**From:** [Jackie Sharp](#)  
**To:** [Zach Torrance-Smith](#); [Justin Turnbull](#)  
**Cc:** [Jamey Ayling](#)  
**Subject:** RE: BL-26-00001 Fields - Updated Public Works Comments  
**Date:** Tuesday, March 31, 2026 8:23:38 AM

I have reviewed BL-26-00001 with Justin. Both items have been addressed (Easement F and BNRR comment added). Thank you.

Please review the attached updated survey for the Fields BLA.

RECORD OF SURVEY

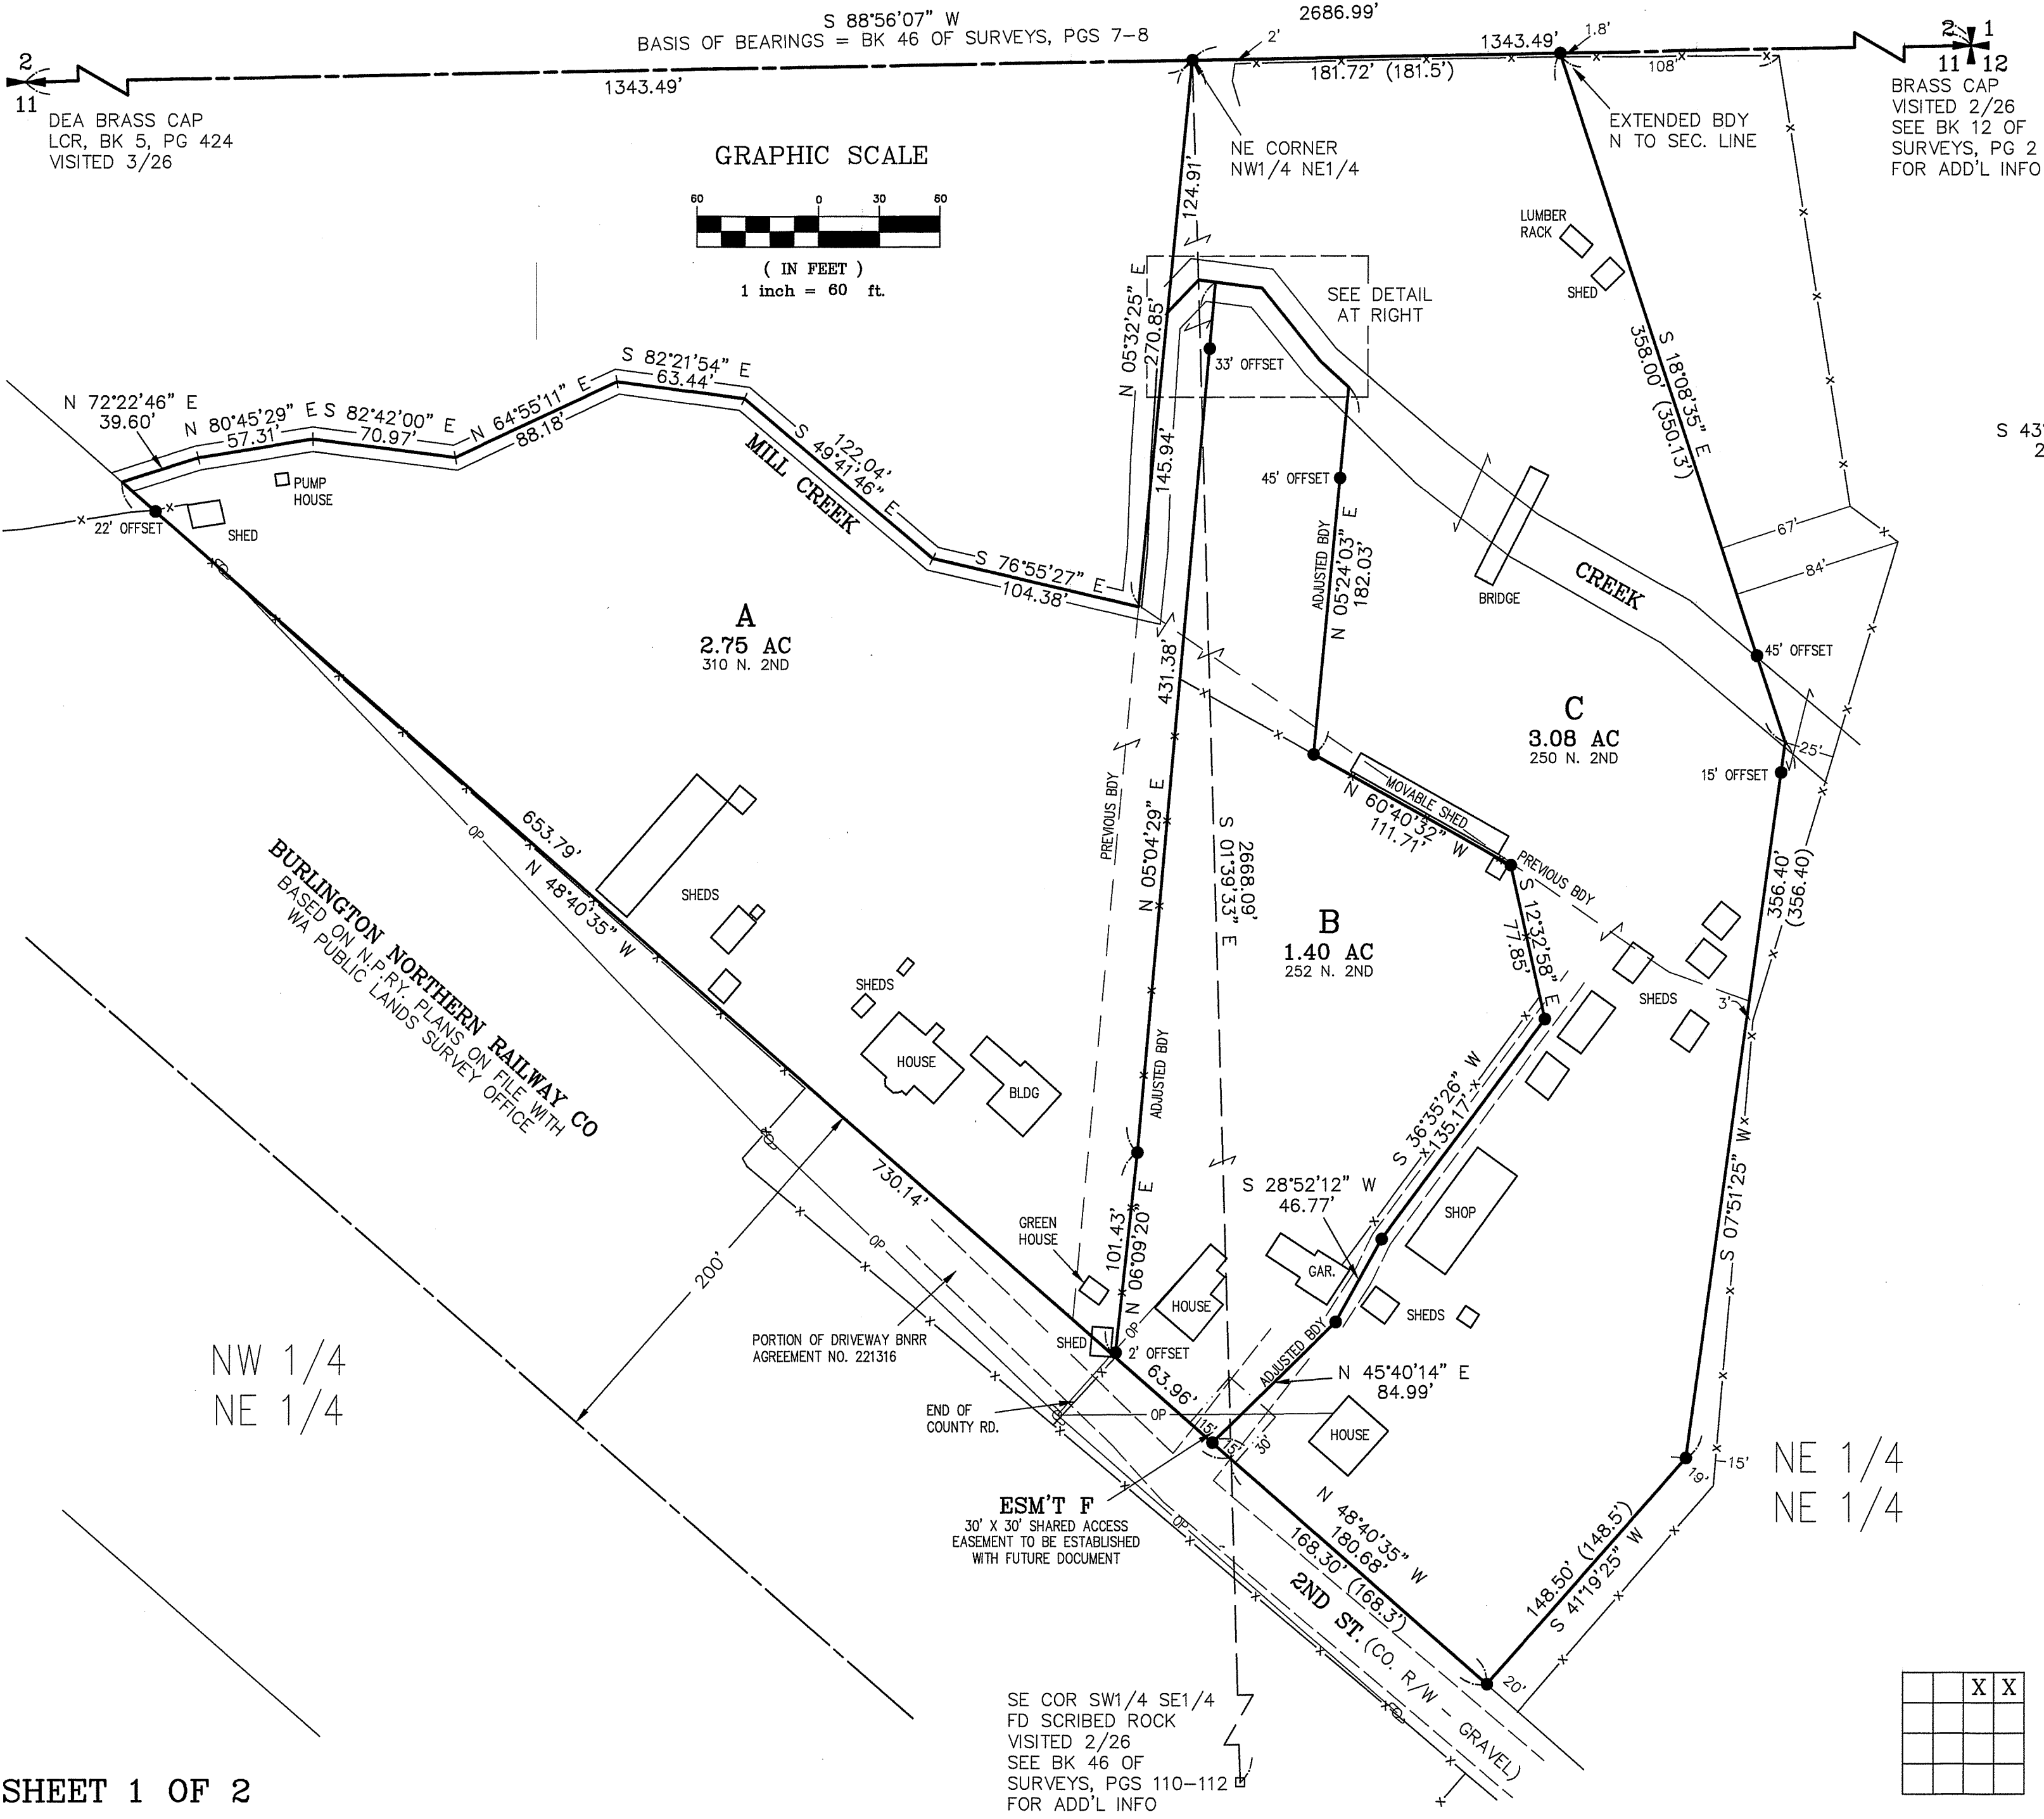
Please see the attached, updated comments from Kittitas County Public Works. Please see the easement language in the Access section.

Zach - Attached is the updated survey with shared access easement. Please review and contact us back with any questions.
